Fore Street

Jeff Tarling <jst@portlandmaine.gov>
To: Jean Fraser <jf@portlandmaine.gov>

Wed, Mar 16, 2016 at 4:54 PM

TREE PROTECTION DETAIL
NOT TO SCALE

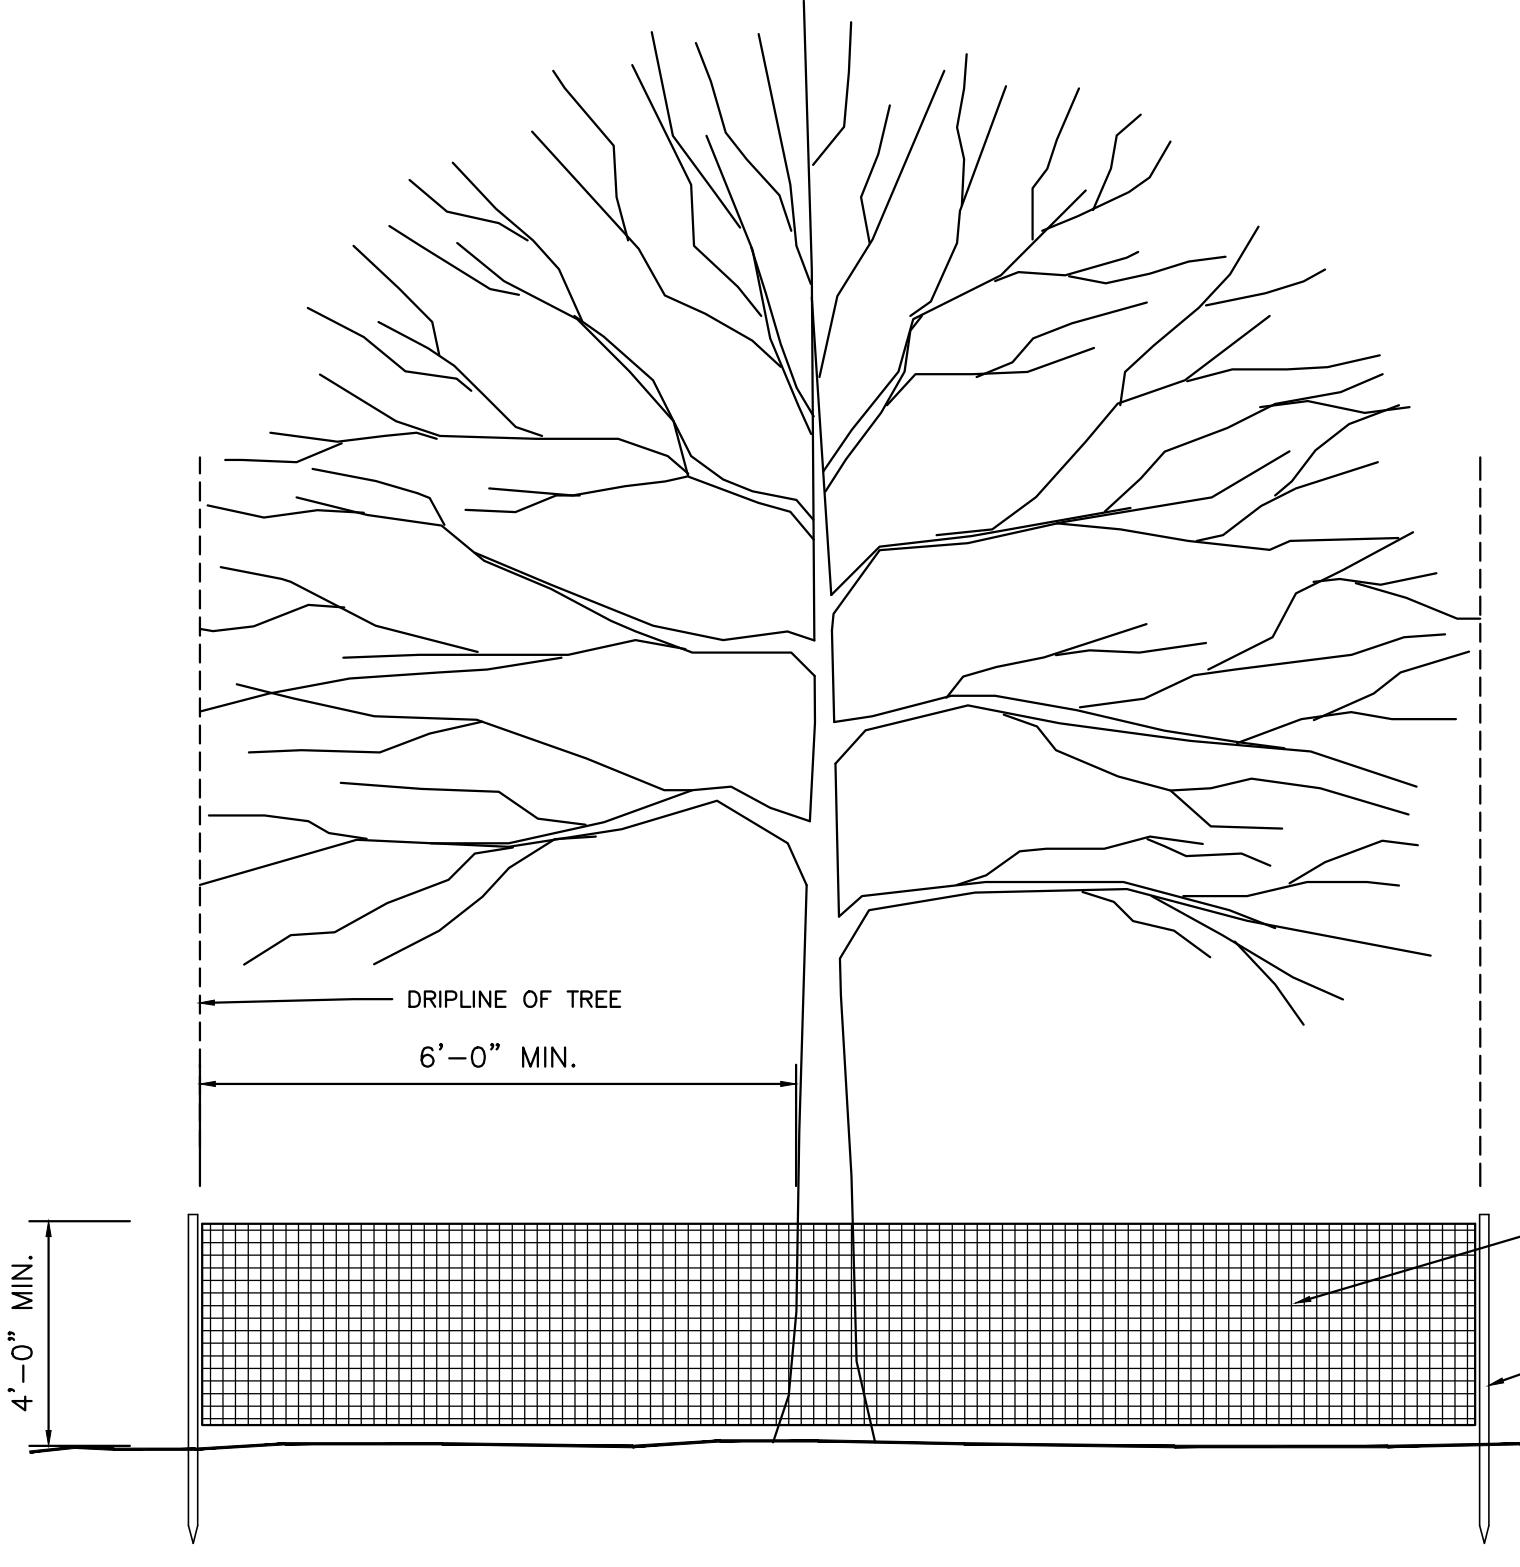
The existing Honeylocust on Fore Street which is 15' east or uphill from the fire hydrant is in good condition and will require 'tree protection' during construction. This should include trunk protection and orange construction fencing around the tree rootzone area. (Condition) The next uphill tree is about 25 feet east of the existing tree and no other space along the Fore Street frontage is open for tree planting.
